Re: Project Solis —Tract J Bulk Land Plat for Mesa del Sol Innovation Park II (101605115947920604)
Project No: PR-2022-007805 (Third Submittal); SP-2025-00084
EPC Plan No: FP-2025-00004

On behalf of Project Solis, Stantec Architecture Inc. respectfully submits this supplemental submission of minor design revisions for final DFT review and approval. The proposed substitutions adhere to the preliminary approvals and findings stated in the EPC *Official Notice of Decision*, dated Aug. 21, 2025 (Plan# FP-2025-00004), and remain in full compliance with the City of Albuquerque IDO codes and regulations. The following revisions have been submitted concurrently to Mesa Del Sol ARC for Step II amendment review and approval.

Overview of Design Revisions:

**A-201**

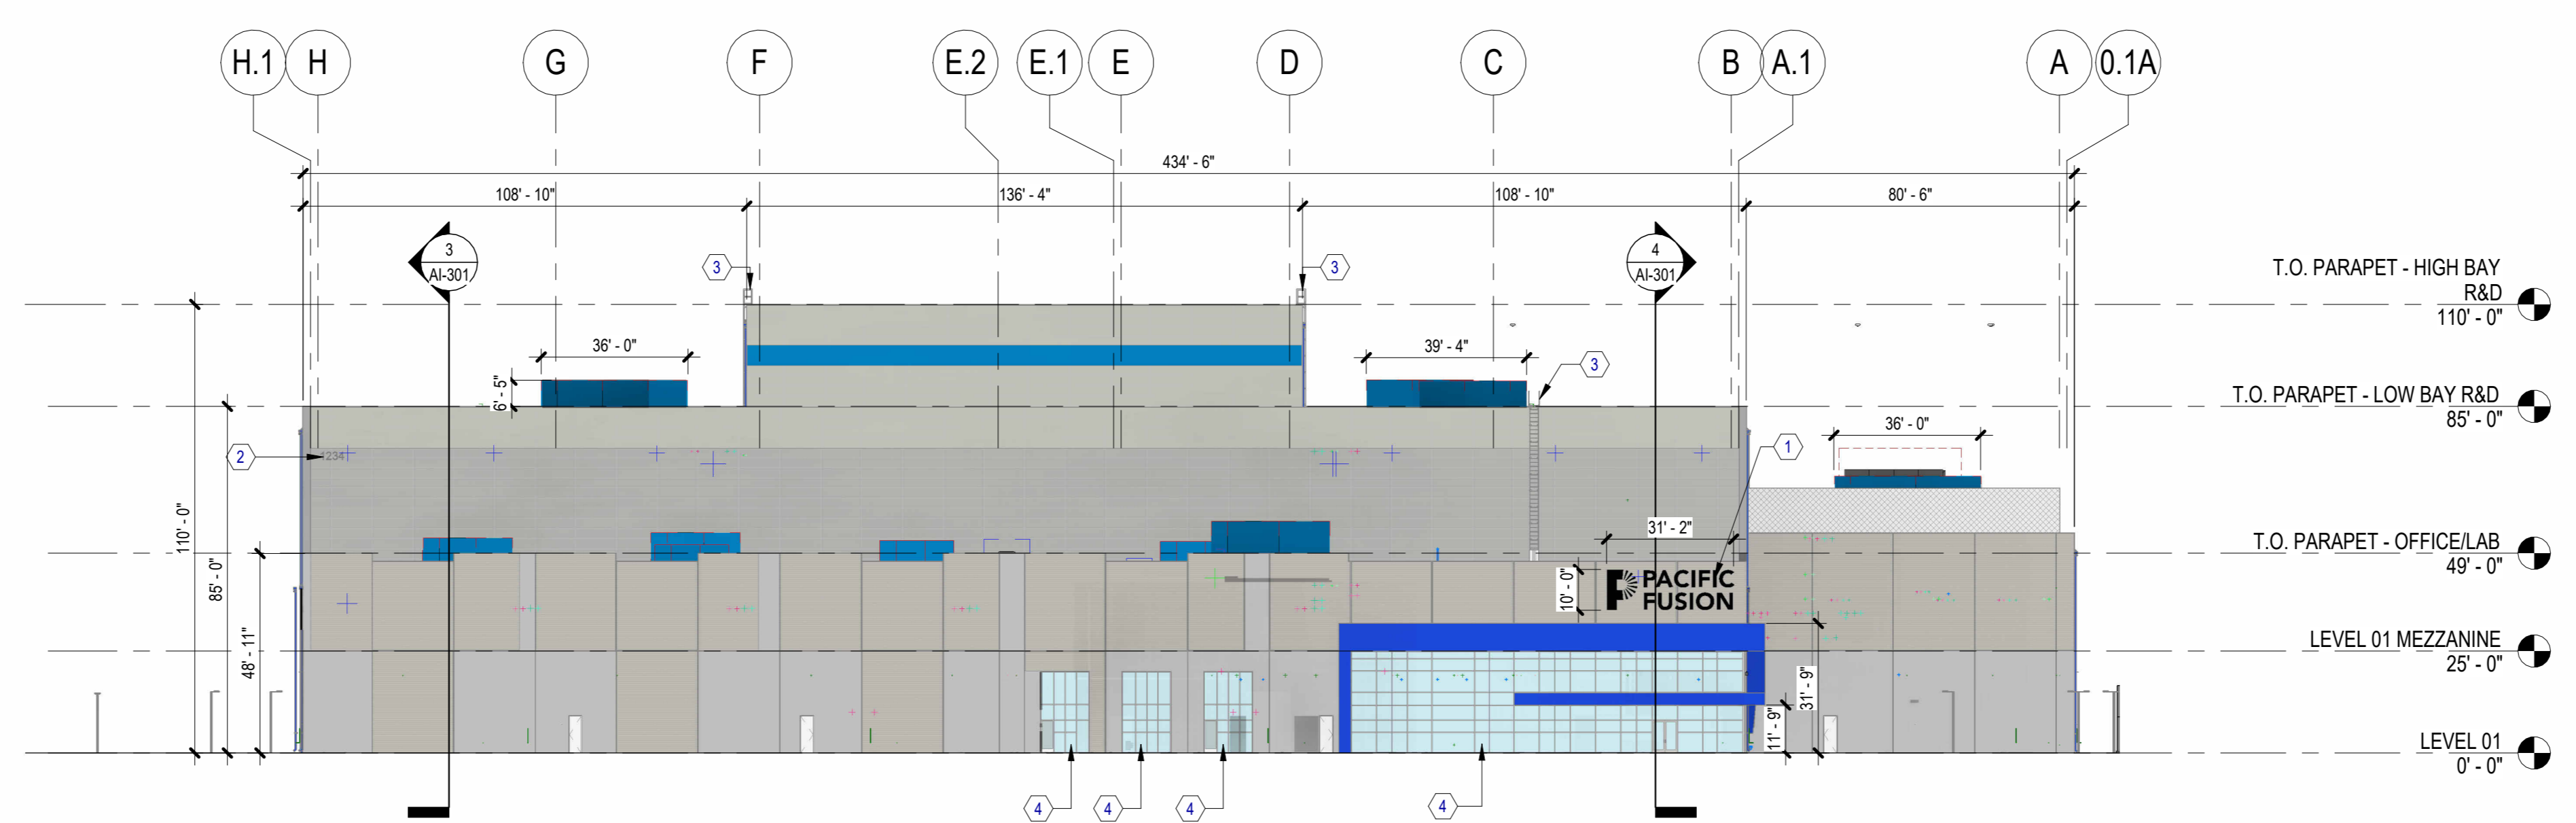
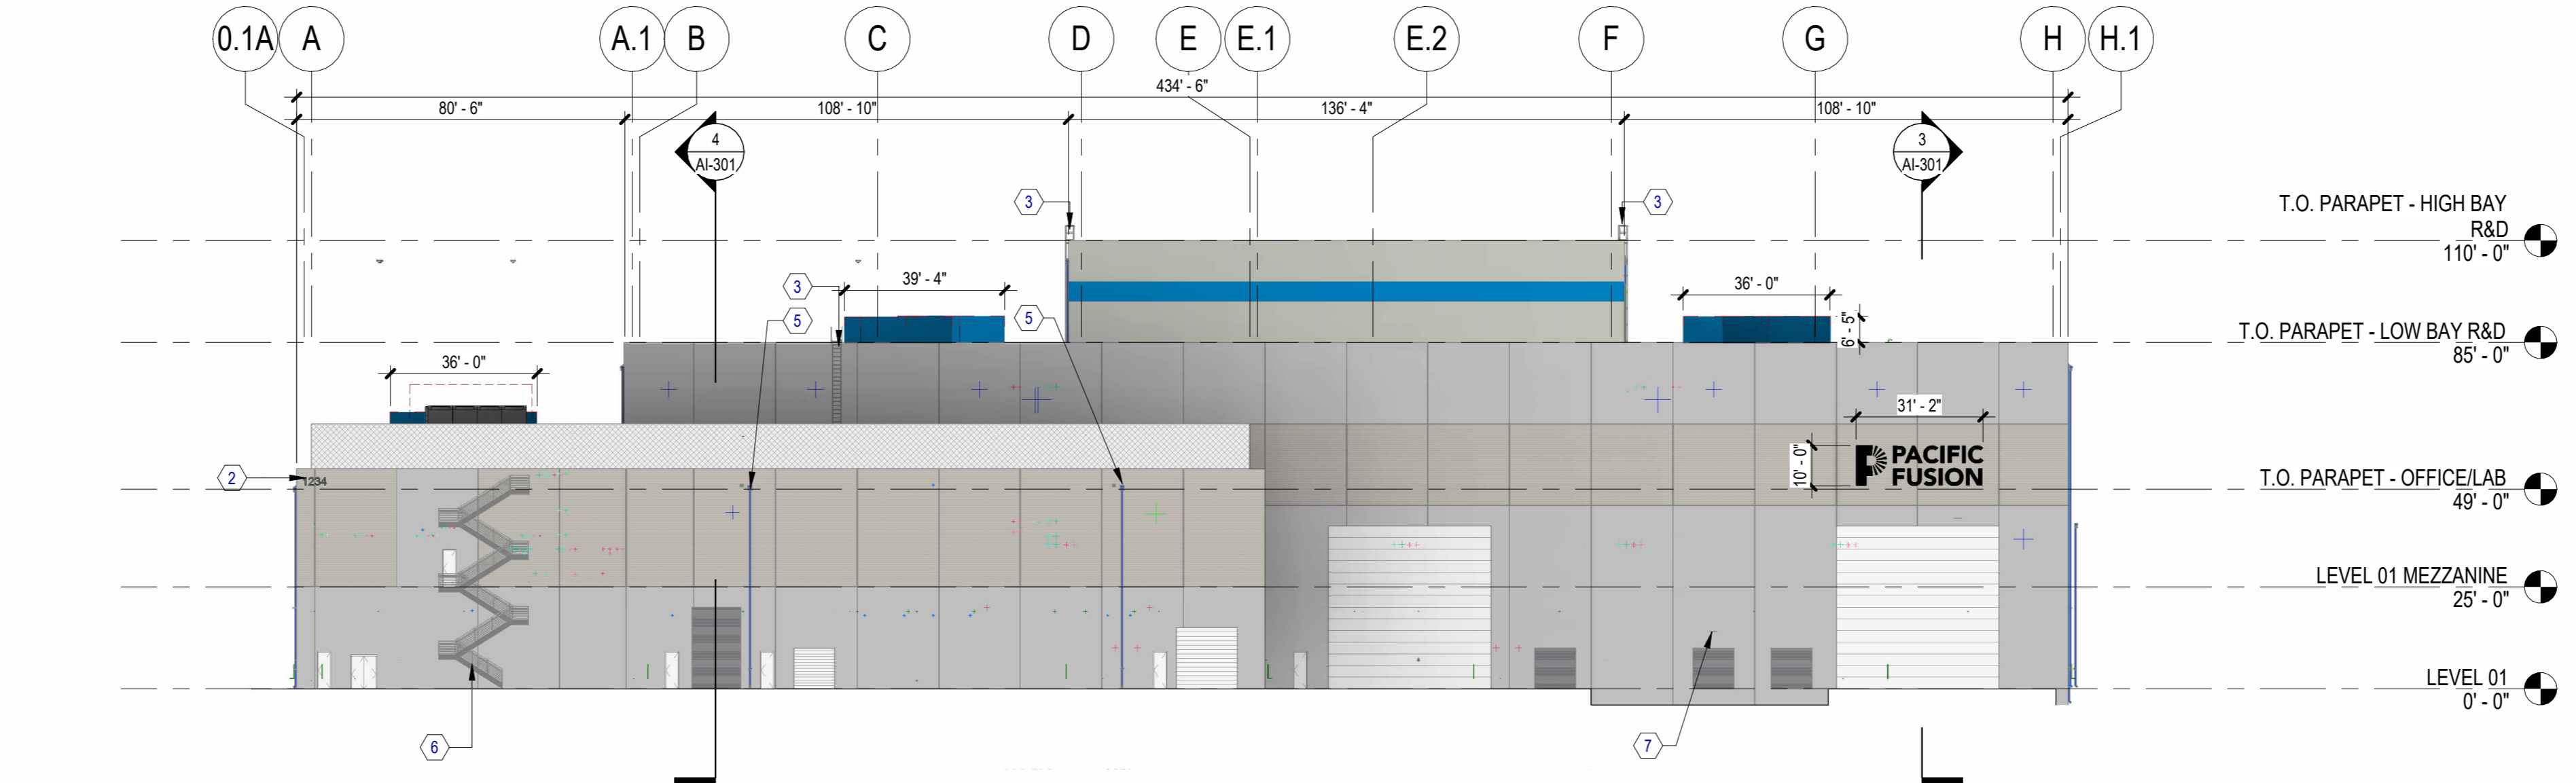
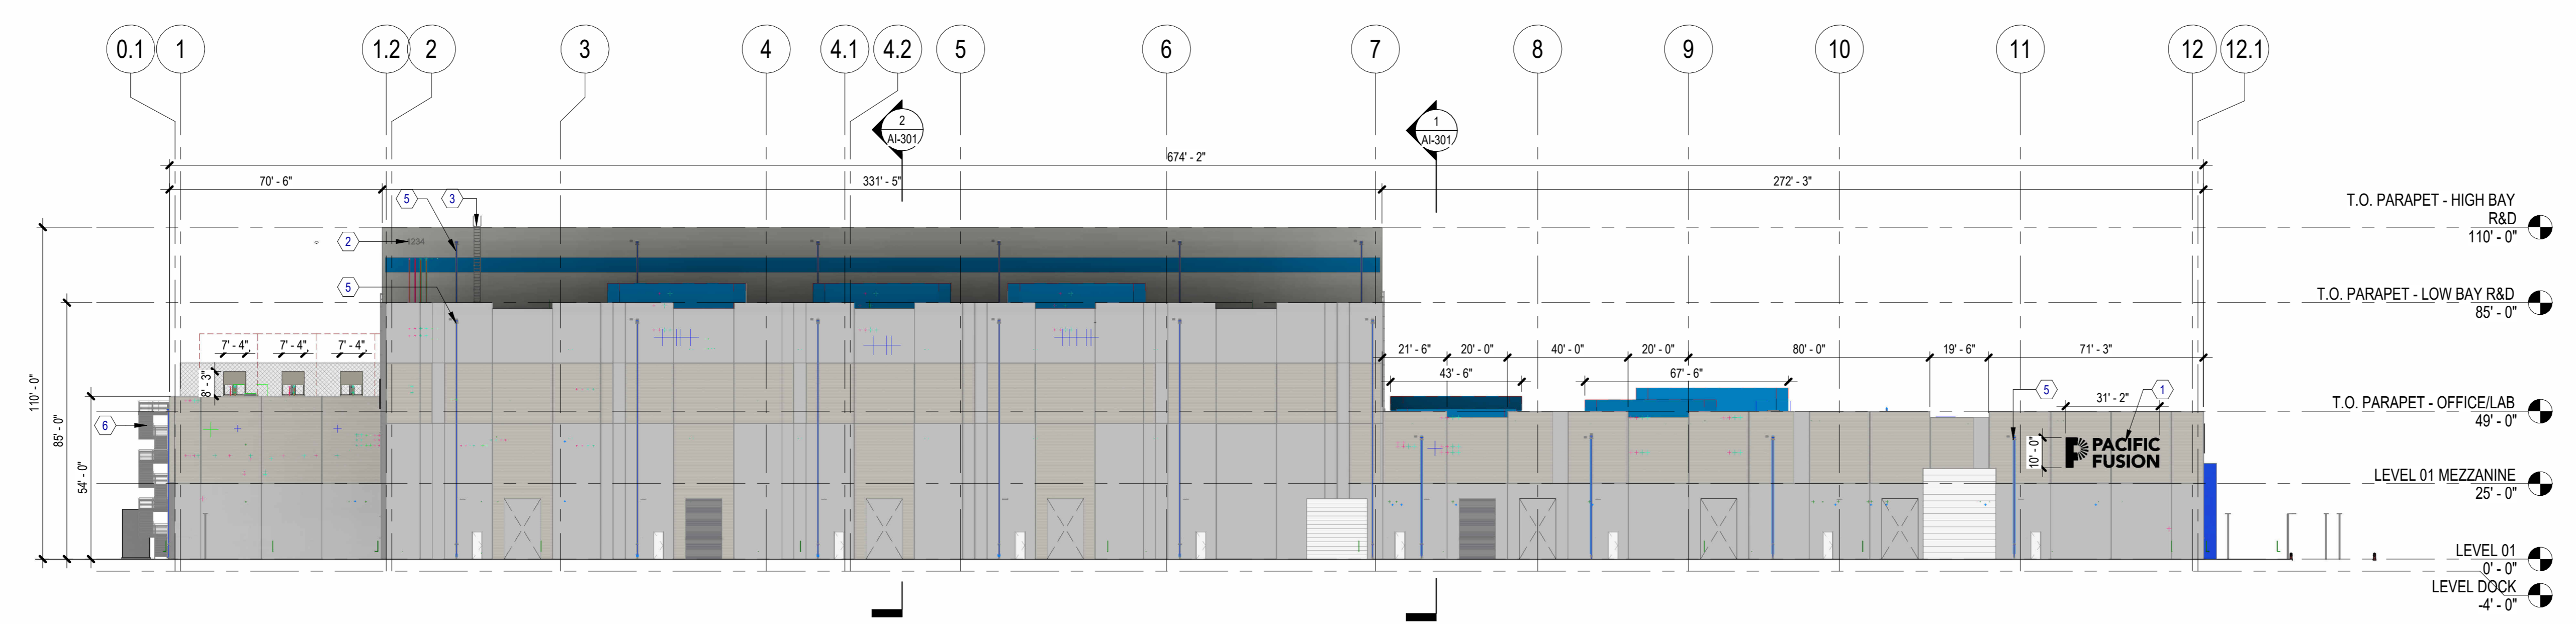
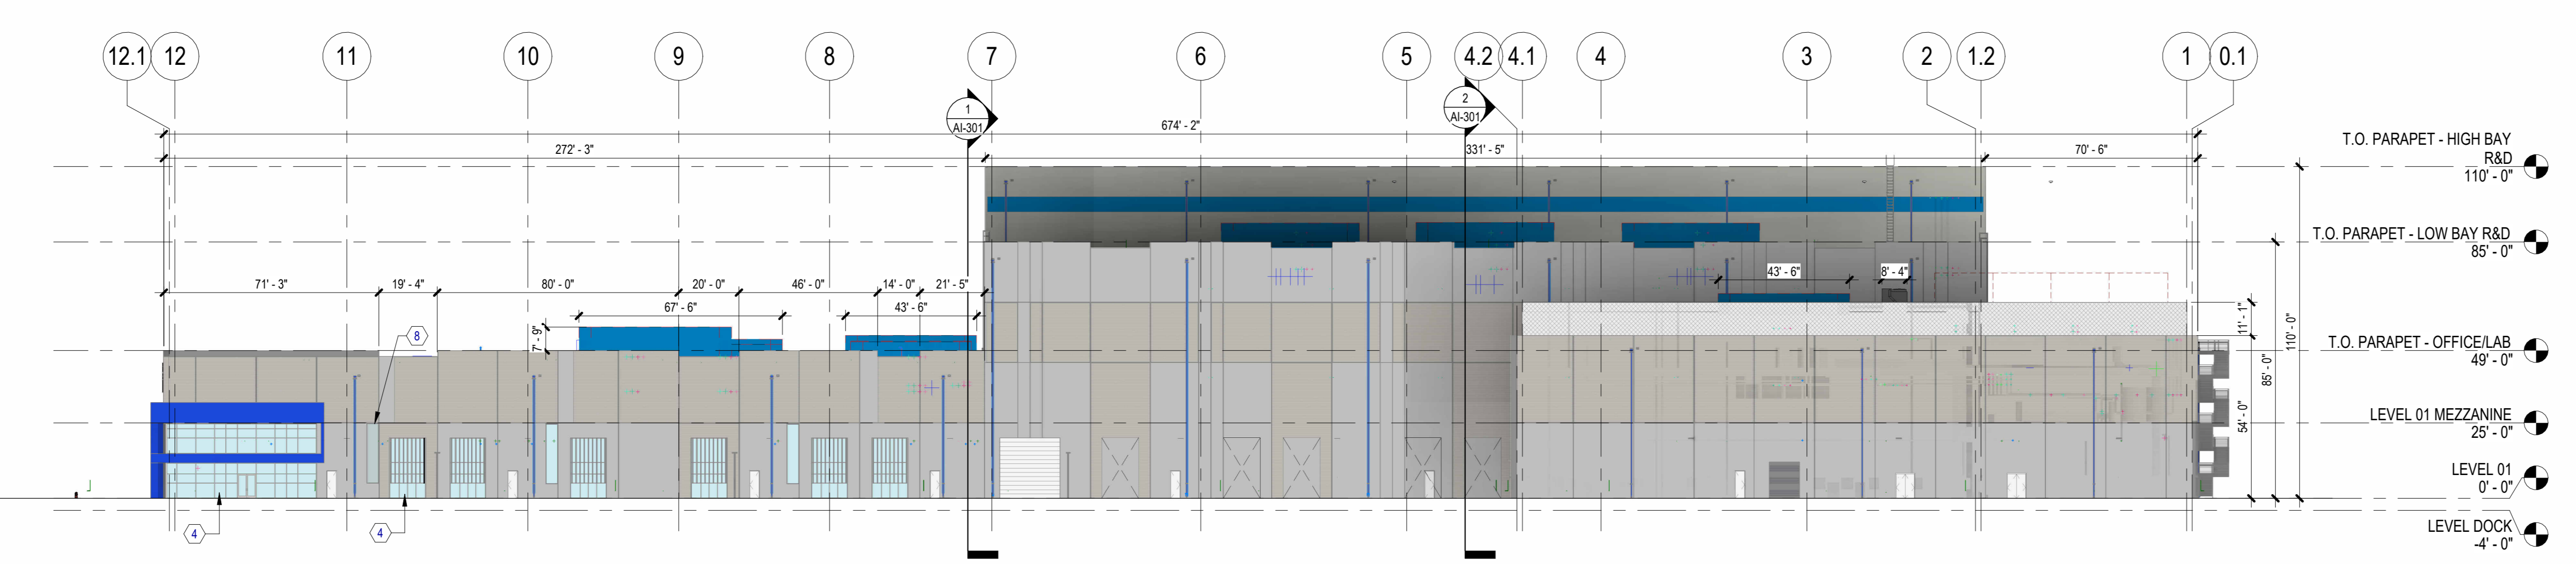
Overall Building – The drawings have been revised to reflect new, relocated or removed openings, including, man doors, overhead doors, and windows. At the high bay, windows have been removed between grids 2 & 7. The revised design remains congruent with the originally approved design, and compliant with all code and zoning requirements.

CUB Facility – The drawings have been revised to reflect the expansion of the CUB facility at the southwest corner of the building, at grid lines A1 thru B4.2. The expansion increases the gross floor area (GFA) from 225,795 sf. to 239,464 sf. a (6% increase). The height of the CUB facility walls also increased from 45' to 54', and equipment screening has been added around the perimeter of the CUB roof to screen rooftop equipment.

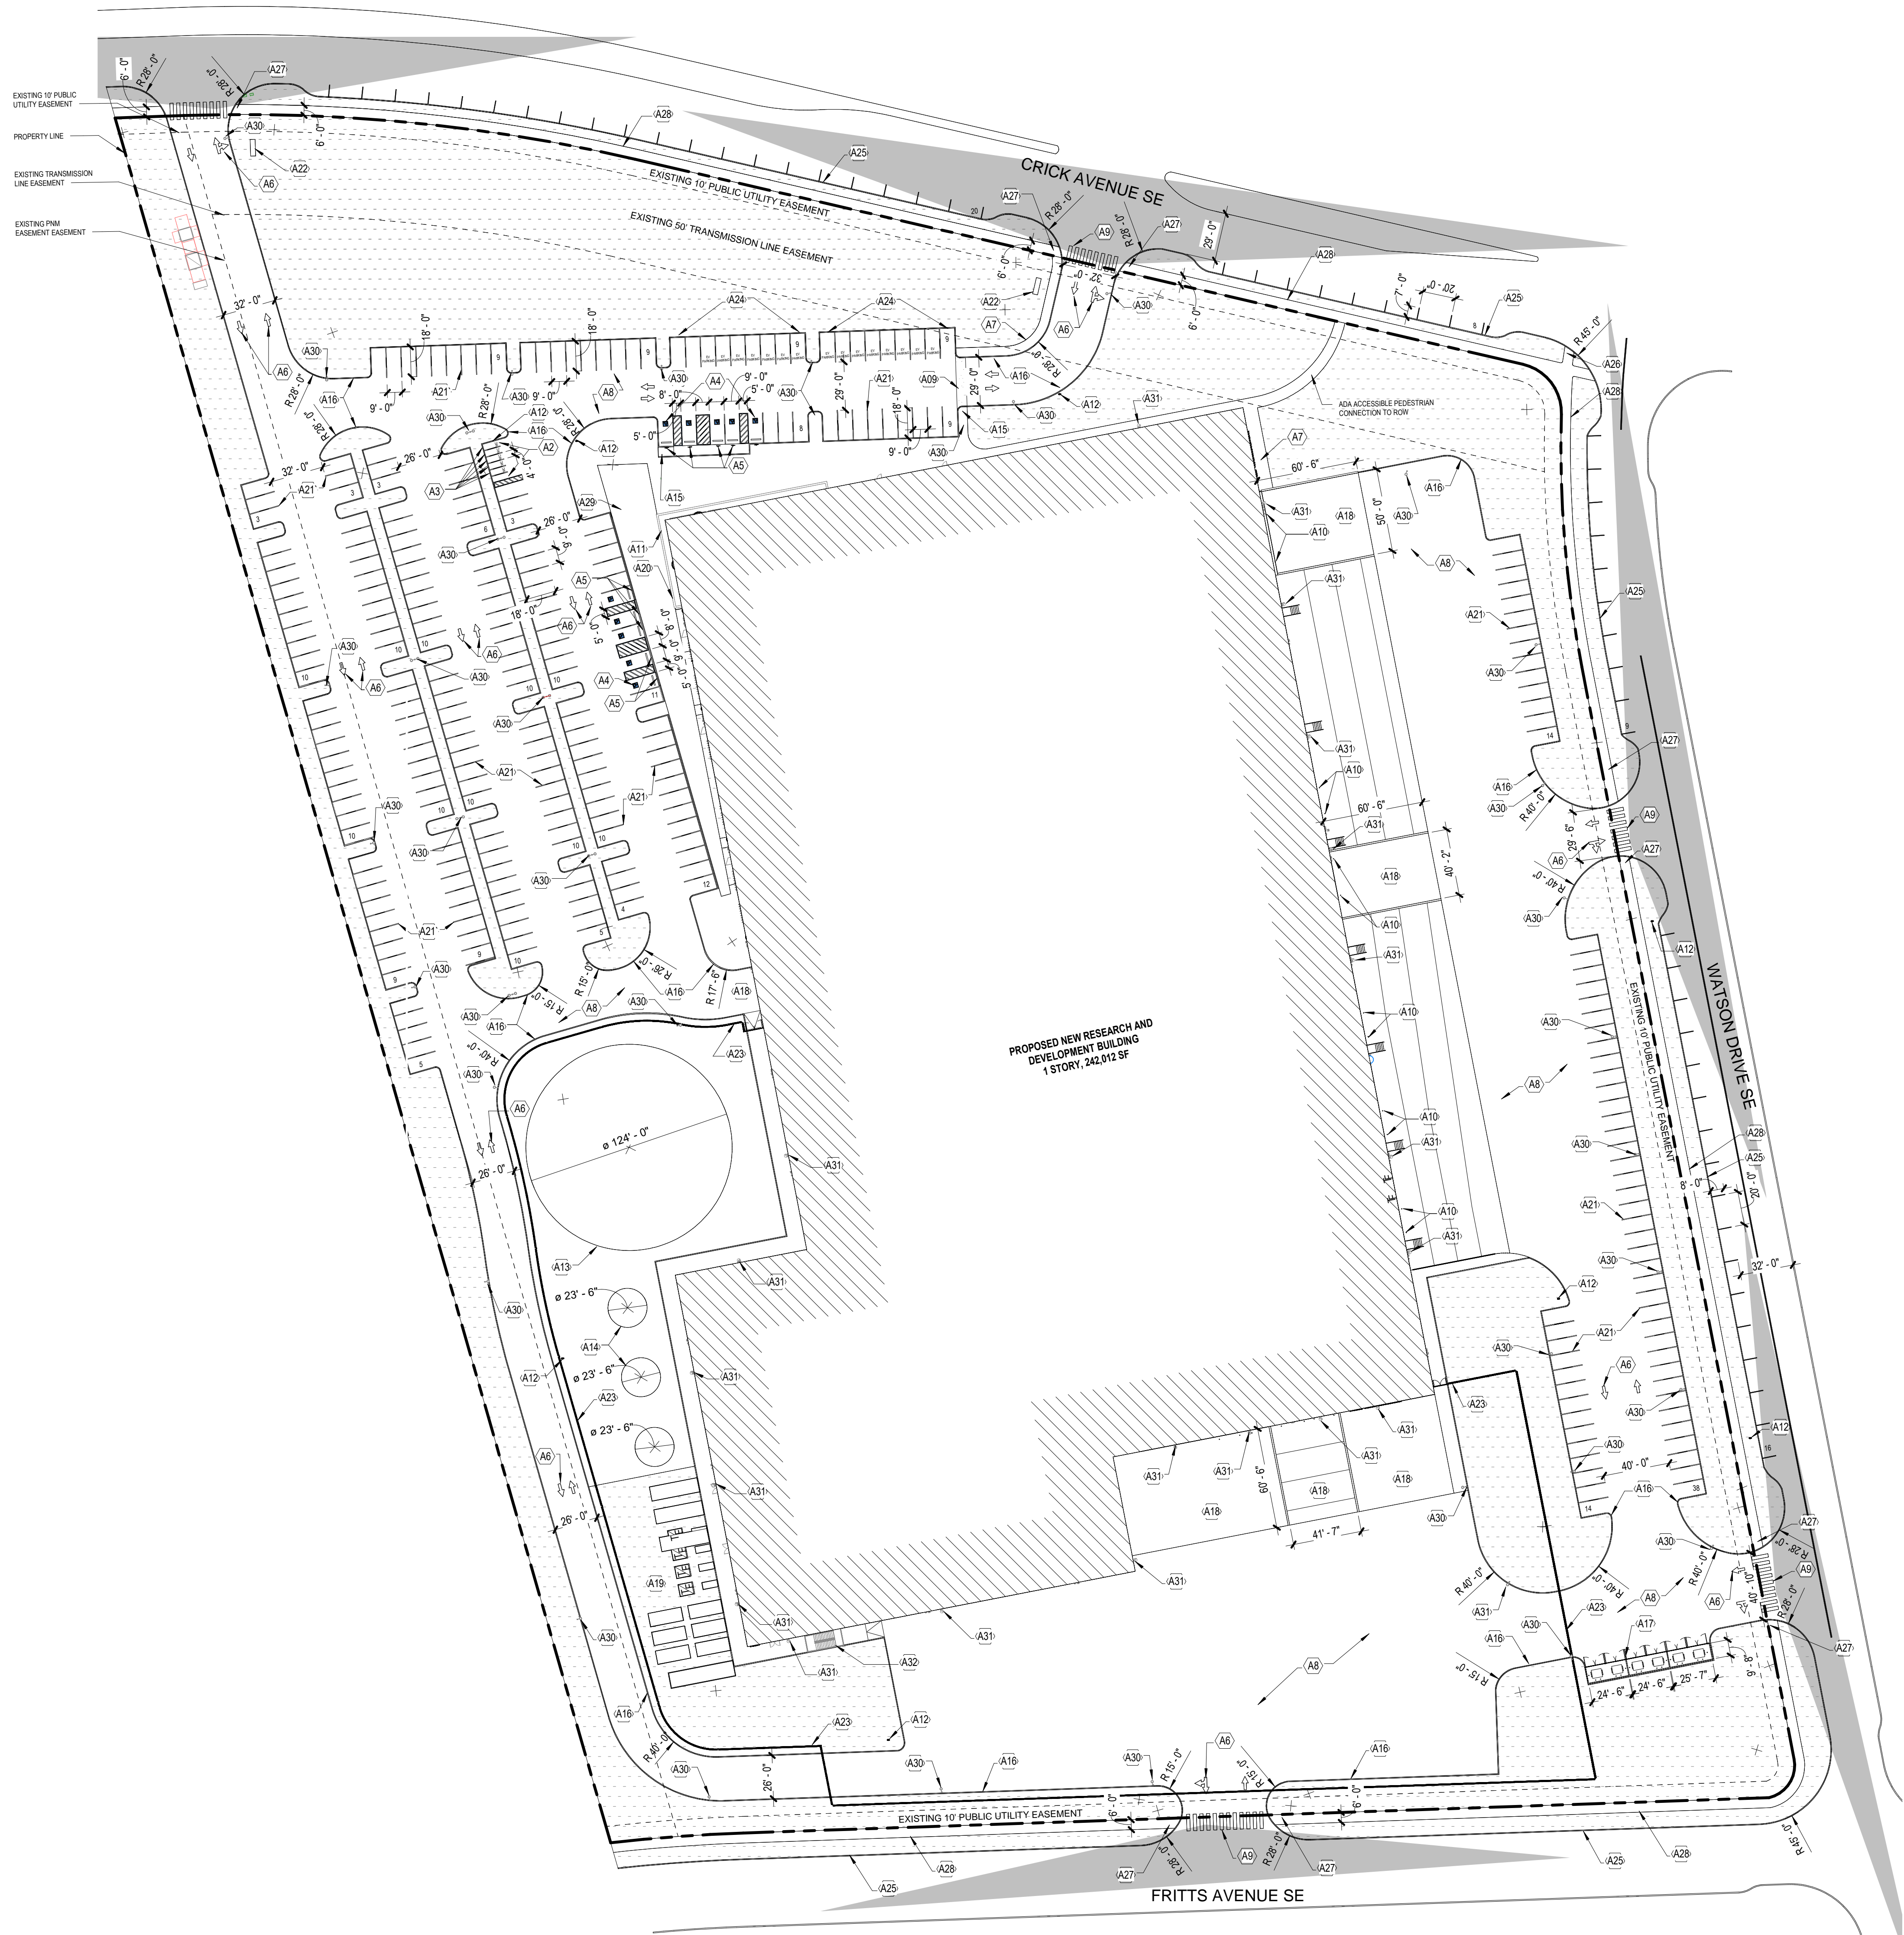
Overall Site Plan – The following revisions have been made to the site design and associated drawings. Based on the total site area of 17.04 acres, 1.67 acres have been impacted by these design revisions – a change of 9.8%. Overall parking increased from 271 spaces to 302 spaces, an increase of 7%. The overall site design was minorly modified to accommodate the larger CUB Facility.

Parking Configuration – Parking has been adjusted around the tank yard, and in various locations throughout the site. Additional parking aisles have been added along the western edge of the site, and near the southeast corner of the building. The overall parking count has increased 7%, to 302 spaces.

Loading Ramps at Building – The two truck loading ramps previously shown at the south of the building have been adjusted and increased in size. Two additional truck loading ramps have also been added to the east side of the building.
